Recommendation Report for Planning Permission for Works or Extension to a Dwelling**REF NO:** FG/32/25/HH**LOCATION:** 1 Greenways Crescent
Ferring
BN12 5EF**PROPOSAL:** Erection of 1.8m high close boarded timber fencing along the eastern boundary.**SITE AND SURROUNDINGS**

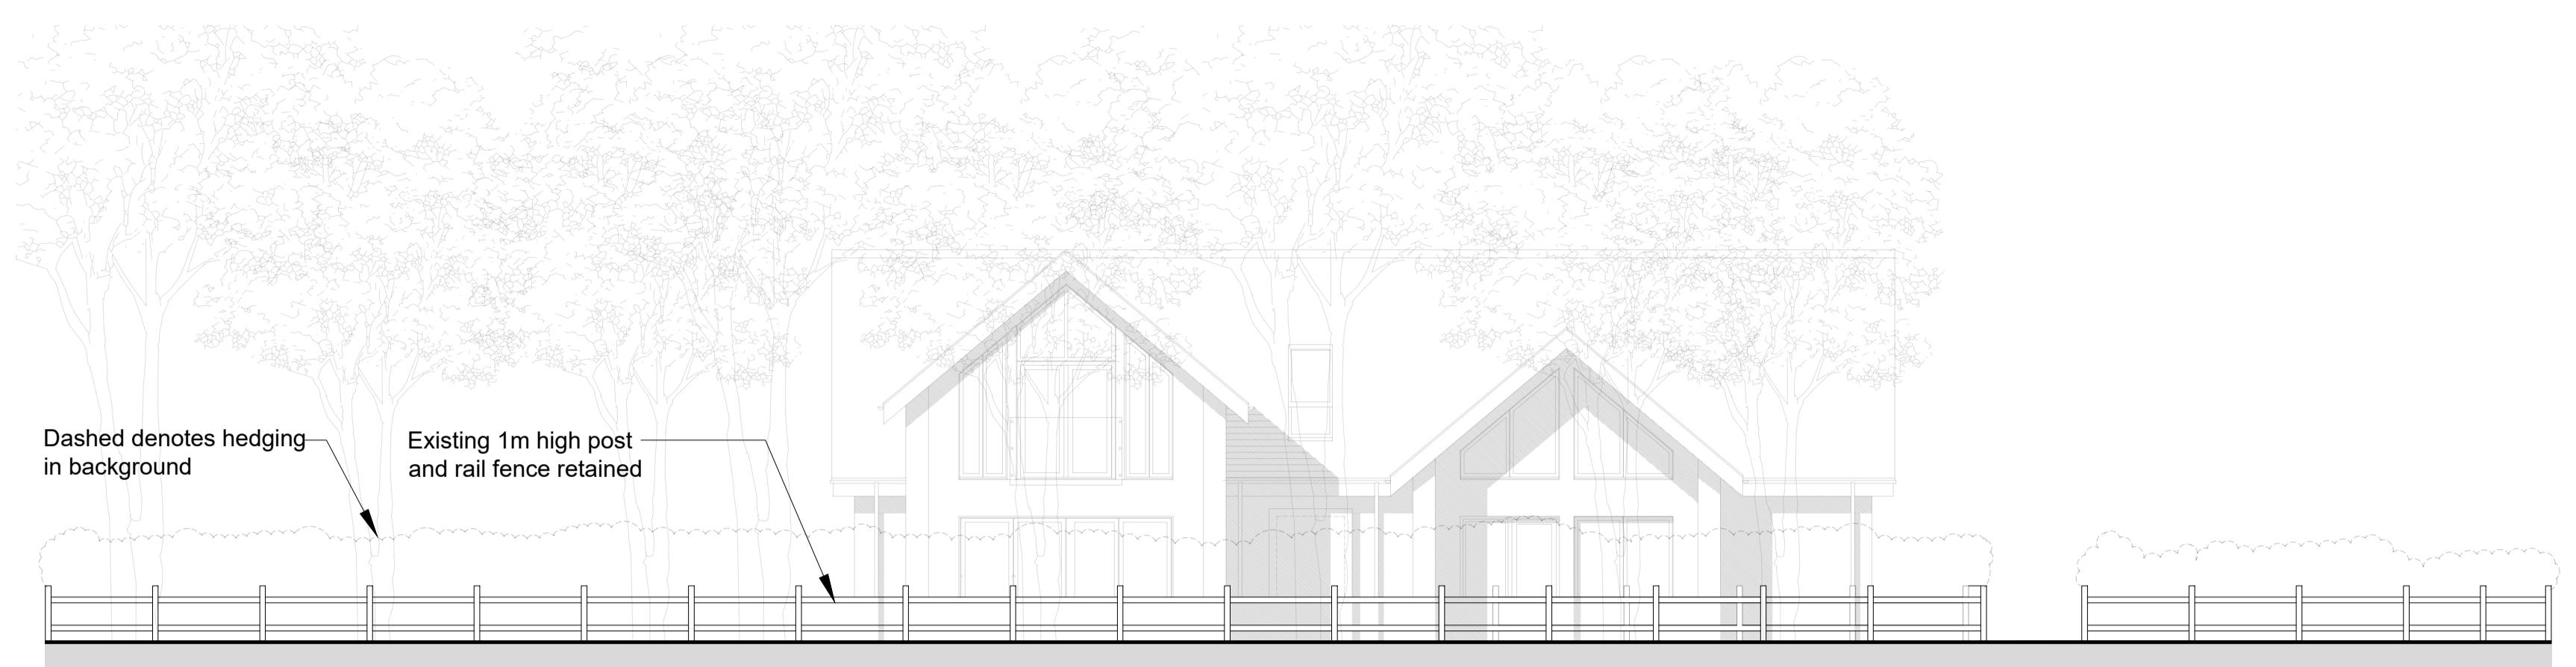
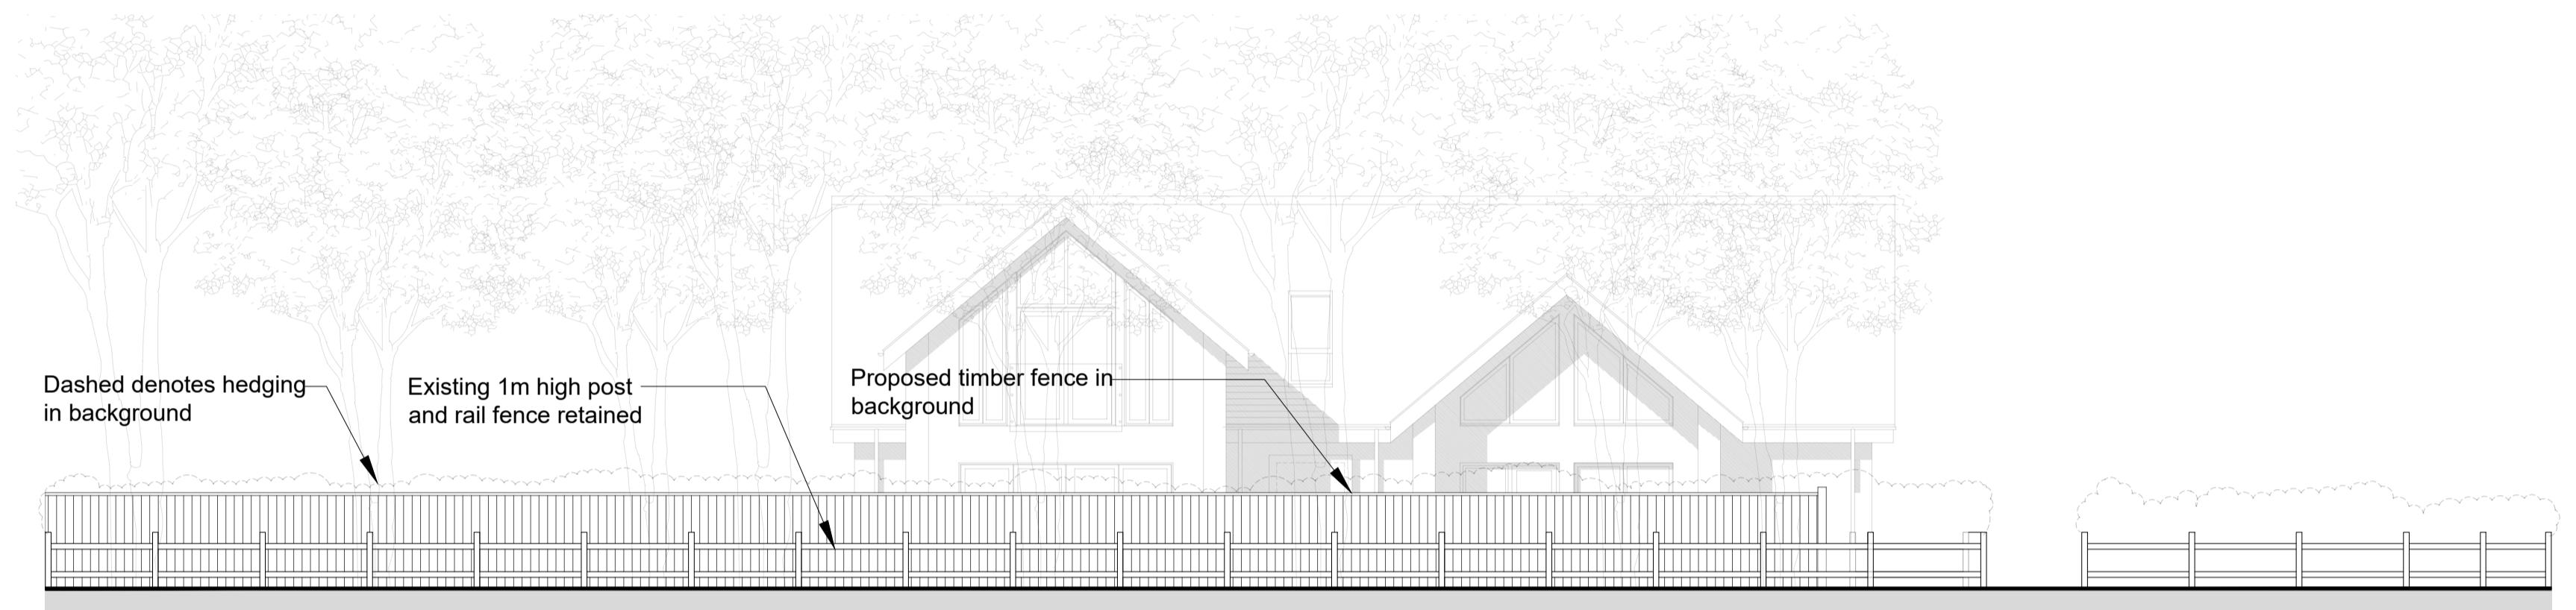
The existing boundary treatment features low-level post and rail fencing with hedging, while neighbouring boundaries are mostly open with some vegetation screening. Greenways Crescent has a green, open and spacious character, of which the existing treatment reflects. The proposed fence, due to its height, extent and continuous form would appear stark and incongruous within this setting therefore it would adversely impact the open character of Greenways Crescent and be out of keeping with the boundary treatments along the road.

Although the proposed fence would be set back from the boundary and positioned behind the maintained existing fence to provide increased private amenity for the applicant, this benefit does not outweigh the harm to the visual amenity of the area. Unlike existing boundary treatments in the locality, the proposal would extend across a large, highly visible frontage and significantly alter the character of the site.

The proposal appears unsympathetic and out of character with the boundary treatment of neighbouring properties. It would be an unduly dominant feature and would harm the character of the area in conflict with D DM1 of the Arun Local Plan.

- 1 The proposed 1.8m high close boarded fence, by reason of its height, siting and extent, would be an incongruous feature in the street scene that results in significant demonstrable harm to the character and open nature of the locality. The development is contrary to policy D DM1(1) of the Arun Local Plan.
